CITY OF ALBUQUERQUE

October 12, 2018

Site: Rohan Subdivision

Re: Drainage Ordinance (14-5-2-1) Violations for Erosion and Sediment Control

EROSION AND SEDIMENT CONTROL PLAN

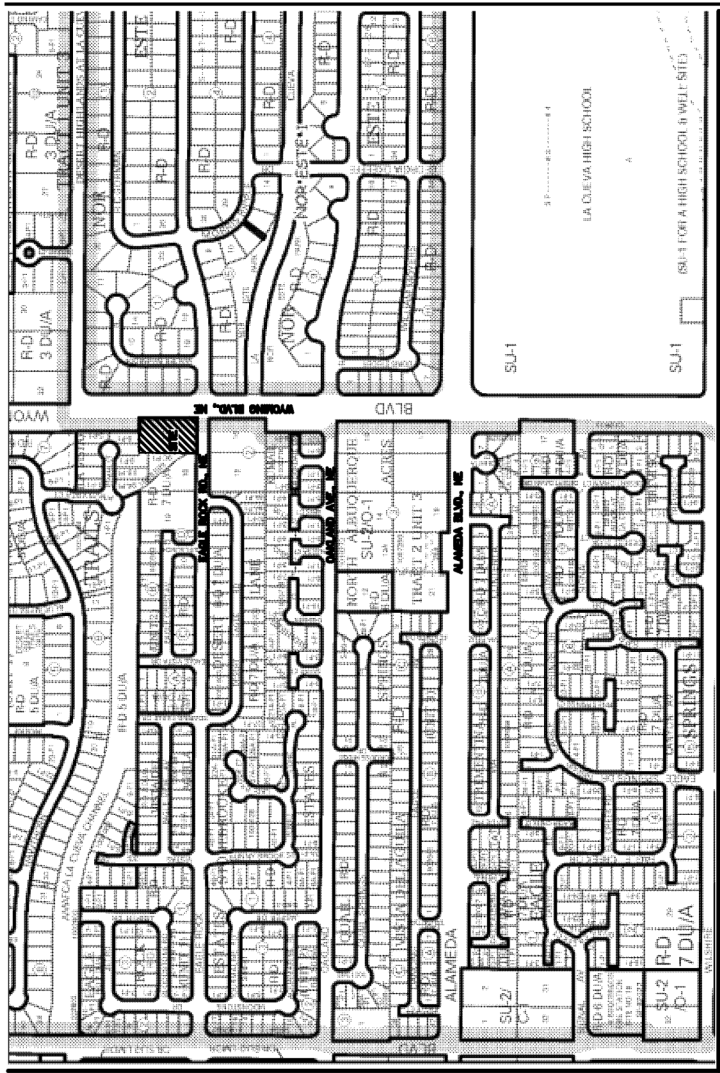
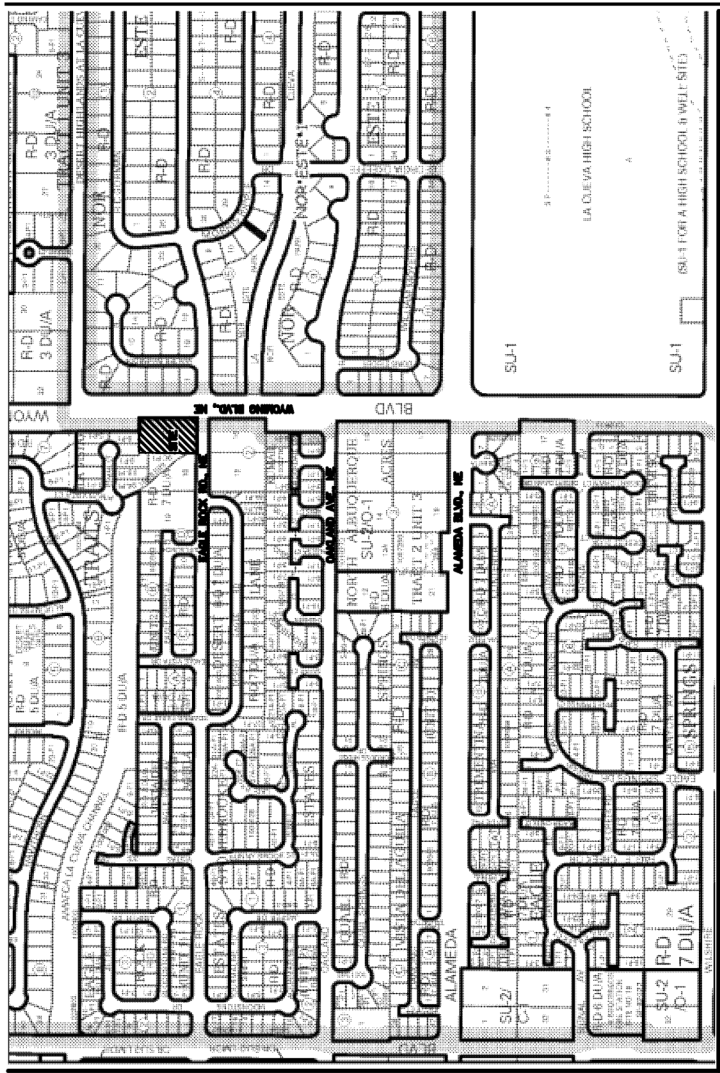
1. The site was not posted per paragraph 1.5 of the NPDES CGP.
2. No sediment BMP for the buffer area along Eagle Rock Ave.
3. Sediment in gutter of Eagle Rock Ave.
4. No inlet protection.
5. There is a disturbed area uphill from the channel with no sediment BMP.
6. No sediment BMP for graded lots .
7. No sediment BMPs for east and west gutters on site.
8. Construction waste pile with litter near channel.
9. There was no waste receptacle.
10. Concrete wash-out in Wyoming ROW.
11. There was no wash-out facility.
12. No sediment BMP at gutter at the south and north ends of the Wyoming ROW and gap in sediment BMP at the south end of Wyoming Blvd.

1. Provide a posting per paragraph 1.5 of the NPDES CGP.
2. Provide a sediment BMP for the buffer area along Eagle Rock Ave.
3. Remove sediment from the gutter in Eagle Rock Ave.
4. Provide inlet protection.
5. Provide a sediment BMP or stabilize the area uphill from the channel with no sediment BMP.
6. Provide a sediment BMP for graded lots.
7. Provide a sediment BMPs for east and west gutters on site.
8. Remove the construction waste pile with litter near channel.
9. Provide a waste receptacle.
10. Remove the concrete wash-out in Wyoming ROW.
11. Provide a wash-out facility.
12. Provide a sediment BMP at gutter at the south and north ends of the Wyoming ROW and gap in sediment BMP at the south end of Wyoming Blvd.
